Our Ref: R/2023/2  
File No: 2023/113693  
Your Ref: SSD-39971796

**Chief Mechanical Engineers Building – SSD 39971796 – Advice on EIS**

Thank you for your correspondence dated 18 January 2023 inviting the City of Sydney Council (the City) to comment on the proposed alterations and additions to the Chief Mechanical Engineers (CME) Building in the Redfern North Eveleigh Precinct which forms part of Tech Central Innovation Precinct.

Camellia tree, *Camellia sasanqua*

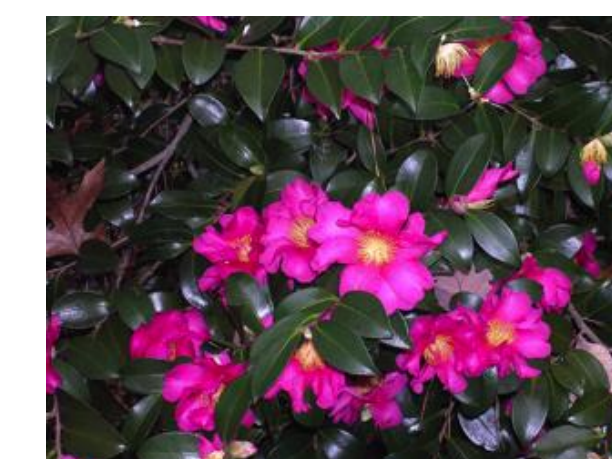
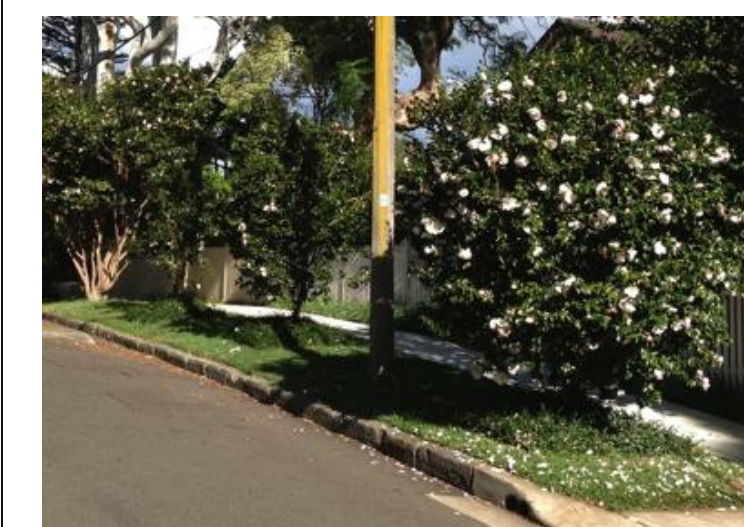
The submitted Landscape Plans indicate new trees will be planted within the site between the Chief Mechanical Engineers Building and boundary fence. The plans indicate the species will be *Camellia sasanqua* with a note stating: "*pruned to small tree, umbrella form.*" The City does not support the selected species or proposal to continually prune the trees to restrict their growth.

Whilst it is acknowledged that small trees along this frontage are preferred so that views are not obstructed to the historical building frontage. It is considered that an alternative species which is less dense than the *Camellia* could be planted without the need for ongoing pruning to be undertaken. This would ensure the City's canopy cover objectives are being contributed to through this development and providing better amenity and environmental benefits to the site rather than continuous pruning of dense foliage trees which are currently shown on the concept plans. Amended landscape plans indicating alternative tree species should be prepared.

Wilson St boundary wall and fence detail

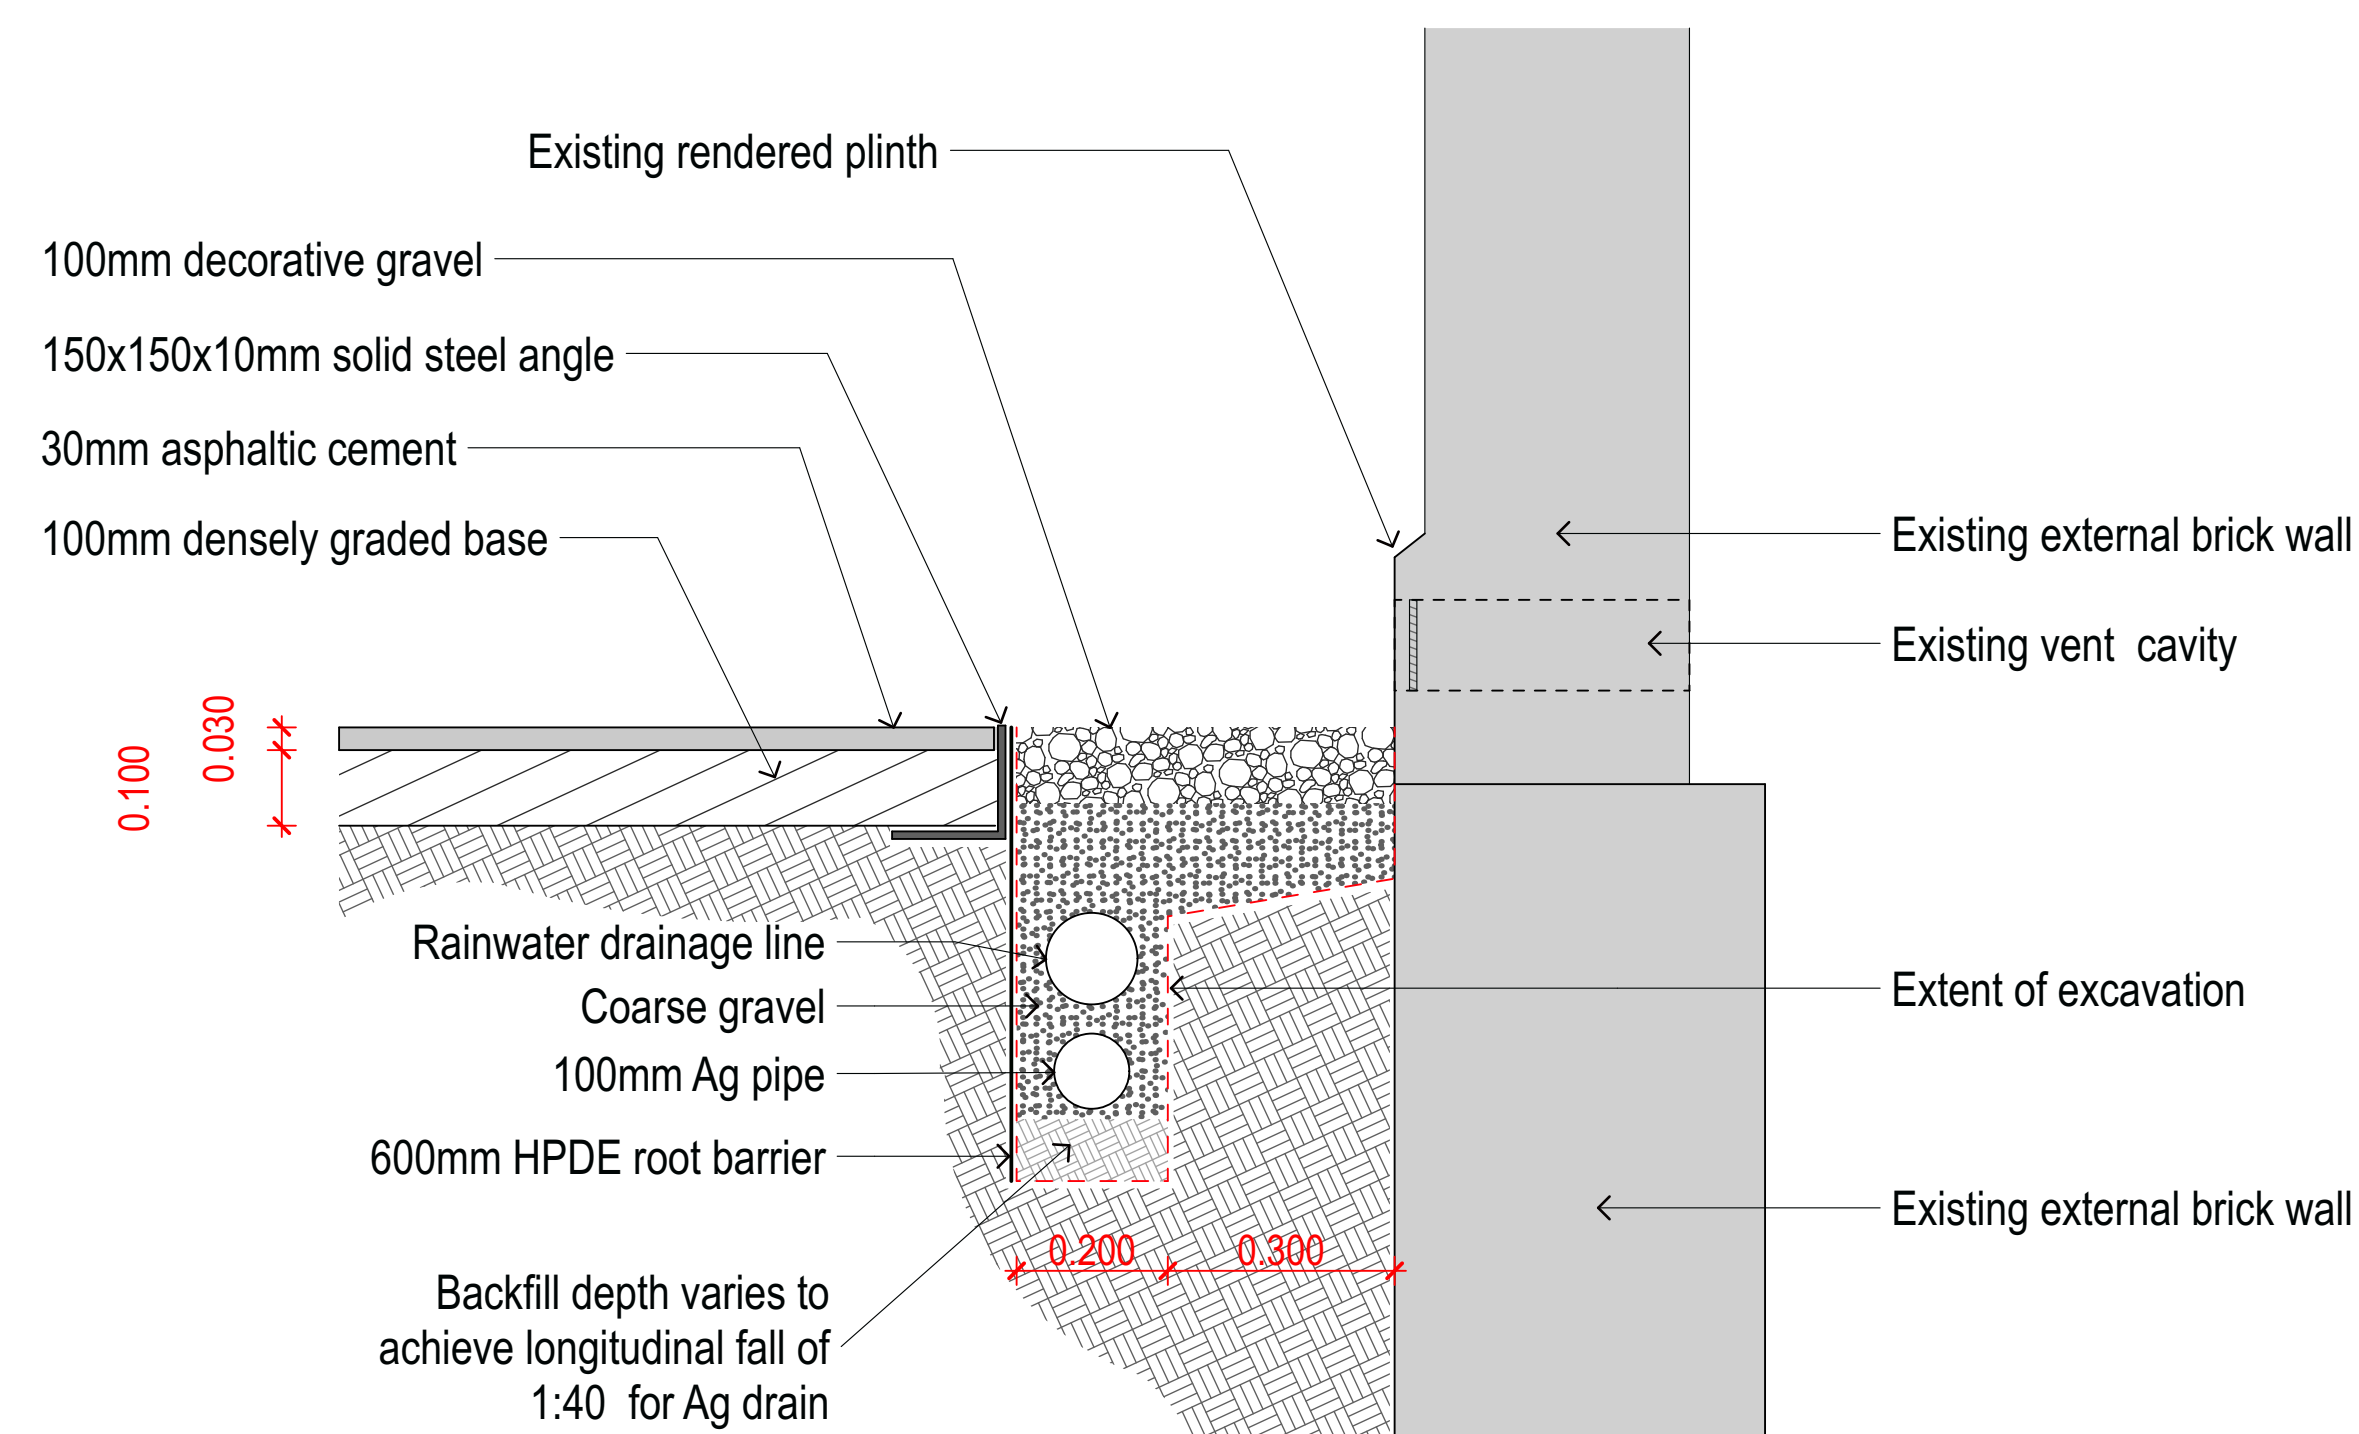
The north-eastern accessible ramp is supported as it only has a minor adverse impact. The proposed steel fence design to replace an existing non original metal fence (which the HIS assesses as a prominent element along Wilson Street) detracts from the significance of the building as it is in very poor condition and has a heavy design that does not compliment the original Victorian style of the CME. The City concurs and support its replacement however the proposed design is not significantly different to the existing.

There is an opportunity here to improve the aesthetic values of the site by proposing a high-quality contemporary design in timber to interpret the original material or simple steel vertical blades spaced to allow visual permeability. There is also potential to

reconstruct the original picket fence in consultation with the heritage consultant based on clear historic evidence as per Burra Charter principles.

It is recommended that an appropriate fence design be proposed that will enhance the Victorian character of the site.

Photographic evidence indicates the original fence on the northern frontage to Wilson Street was a low timber picket fence with no plinth at the base. The existing fence includes a low wall with metal palisade fence that was installed in the 1990s. The low wall potentially retains soil levels on the site while a 1000mm high steel fence to match City of Sydney Park Fence Design, custom manufactured and finished in dark grey micaceous iron oxide coating, mounted atop new brick wall is proposed on the Wilson Street Frontage.

The proposed fence design is based on a typical City Parks manual fence detail and not sympathetic to the heritage significance of the subject site. The design in its current form is not supported from a landscape perspective.

There is opportunity to reinstate original picket fence up to 1200mm height with no brick plinth. The proposed fence should be original heritage fence design based on photographic evidence.
